CITY OF ALBUQUERQUE

July 22, 2016

Re: Construction Seminars Renovations
7915 Prospect Ave NE
Traffic Circulation Layout
Architect's Stamp 07-20-16 (H17D104)

PROPOSED SITE PLAN - TRAFFIC CIRCULATION LAYOUT SUBMISSION

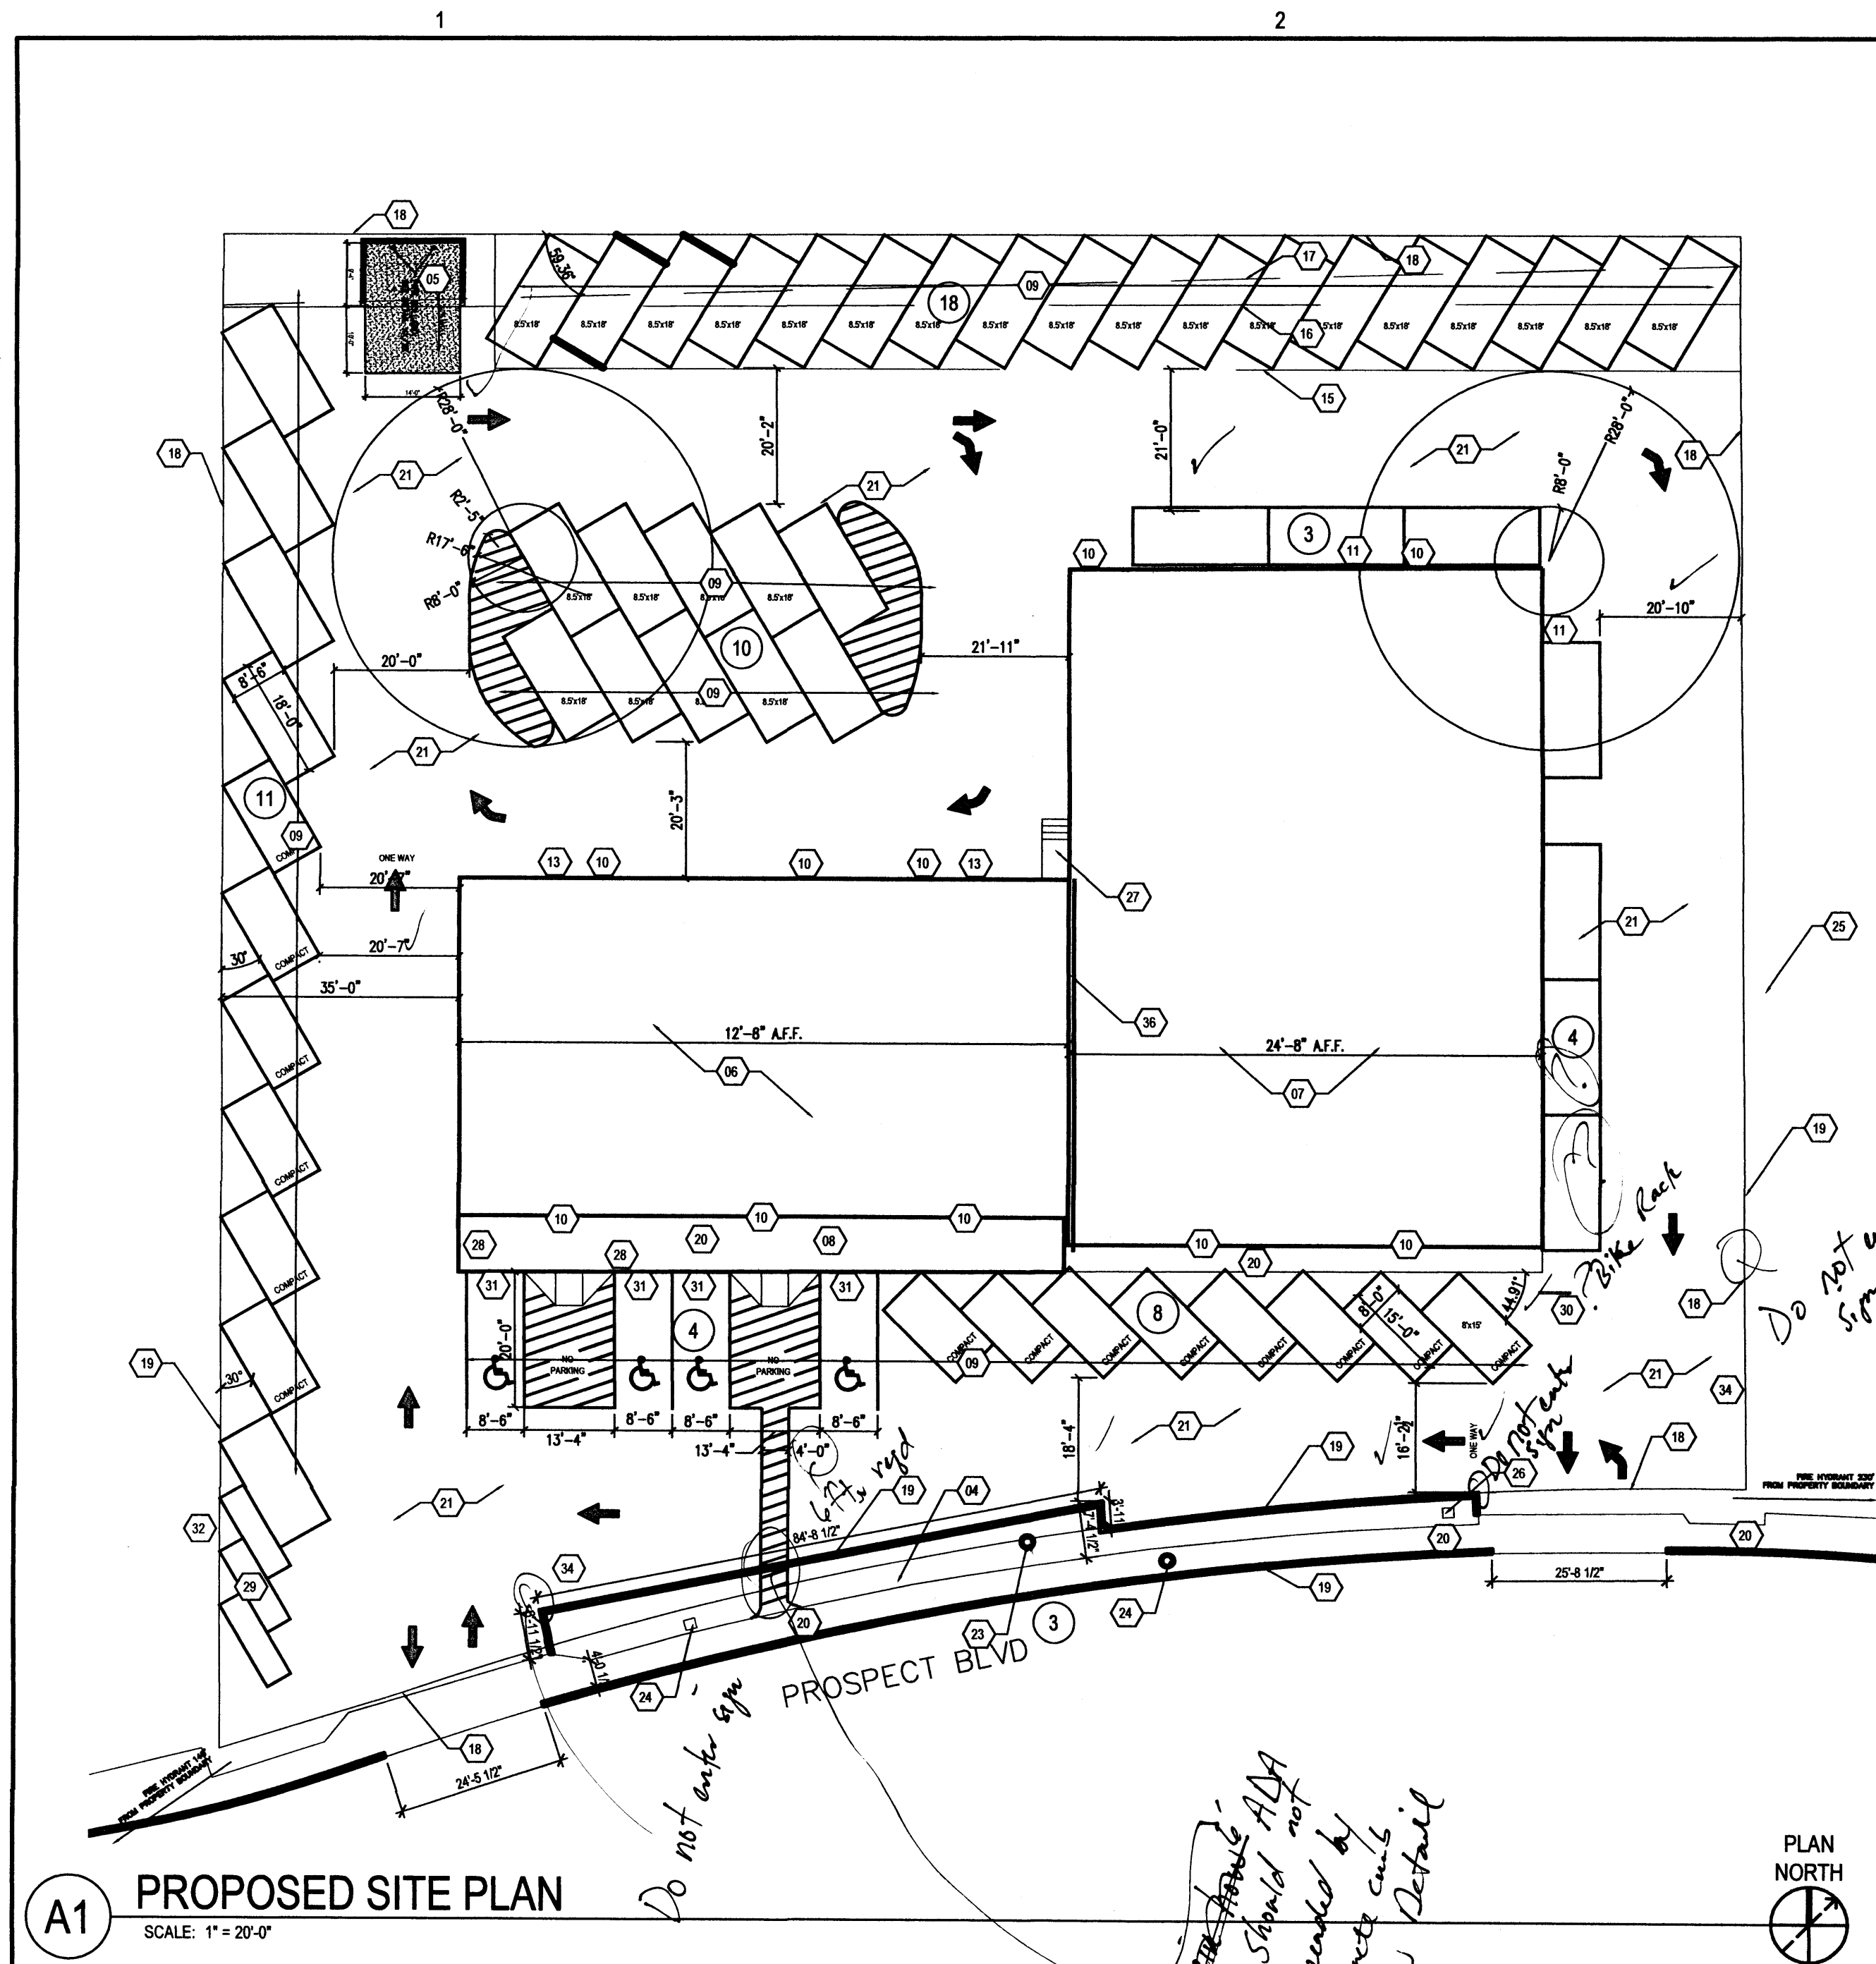
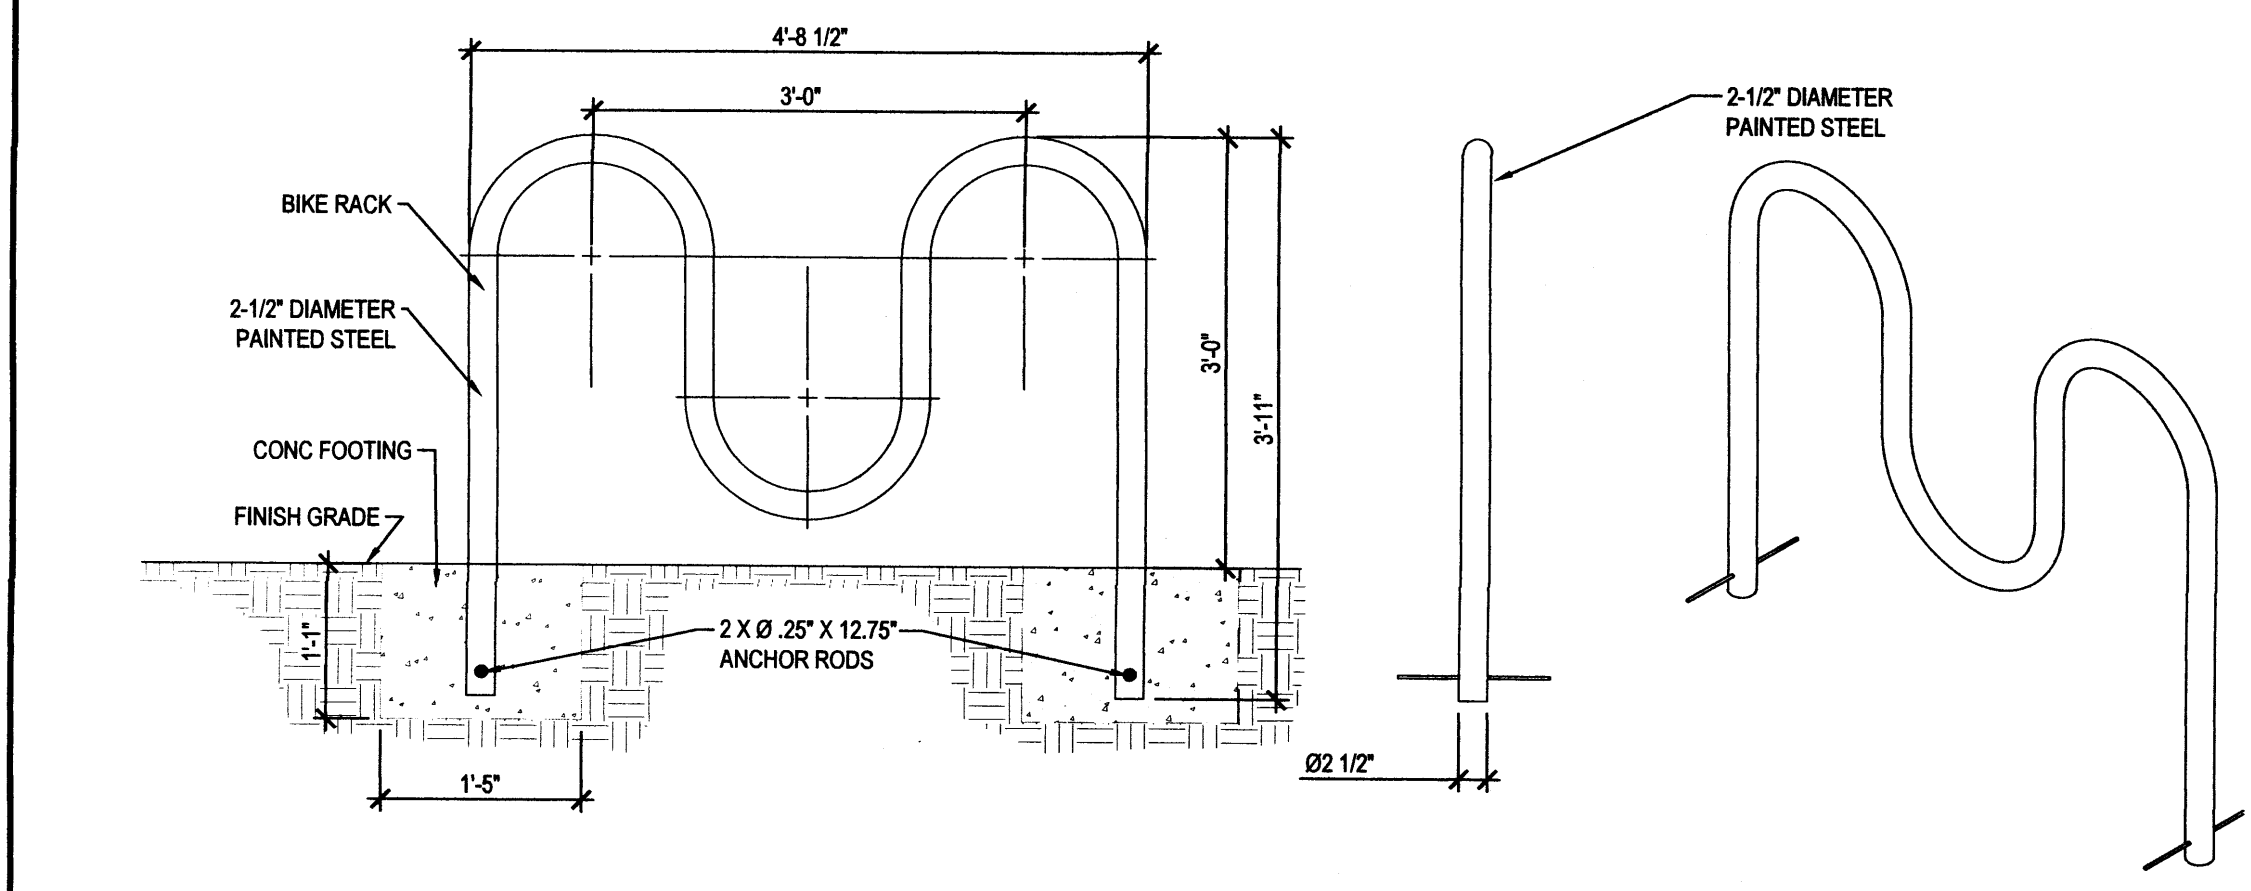
1. Please show a vicinity map showing the location of the development in relation to streets and well known landmarks.
2. Identify the right of way width, medians, curb cuts, and street widths on Prospect Ave NE.

3. The 6 ft. wide ADA accessible pedestrian pathway required from the public sidewalk to the building entrances must be clear of any curb lines. Please clearly show this pathway and provide details.

4. Provide a detail of all ADA accessible ramps onsite.
5. Provide dimensions of motorcycle parking. (Zoning Code, 14-16-31, C.)
6. One-way vehicular paths require pavement directional signage and a posted "**Do Not Enter**" sign at the point of egress. Please show detail and location of posted signs.

7. Please provide a sight distance exhibit (see the *Development Process Manual, Chapter 23, Section 6, Part B.12 Visibility for Driveways*).
8. Please add the following note to the clear sight triangle: "Landscaping and signage will not interfere with clear sight requirements. Therefore, signs, walls, trees, and shrubbery between 3 and 8 feet tall (as measured from the gutter pan) will not be acceptable in this area."

9. Please specify the City Standard Drawing Number when applicable.
10. Add keynote 11 to all overhead garage doors.
11. Provide conformation from zoning the amount of parking required and provided is correct.

12. Clarify the limits of the portal that covers the front walkway.

13. Show the existing property lines.
14. Please add a note on the plan stating "All improvements located in the Right of Way must be included on the work order."

15. Show the 3 curbside parking spaces called out on the parking total requirements. If On-street parking credit is required please follow item to request On-Street parking.
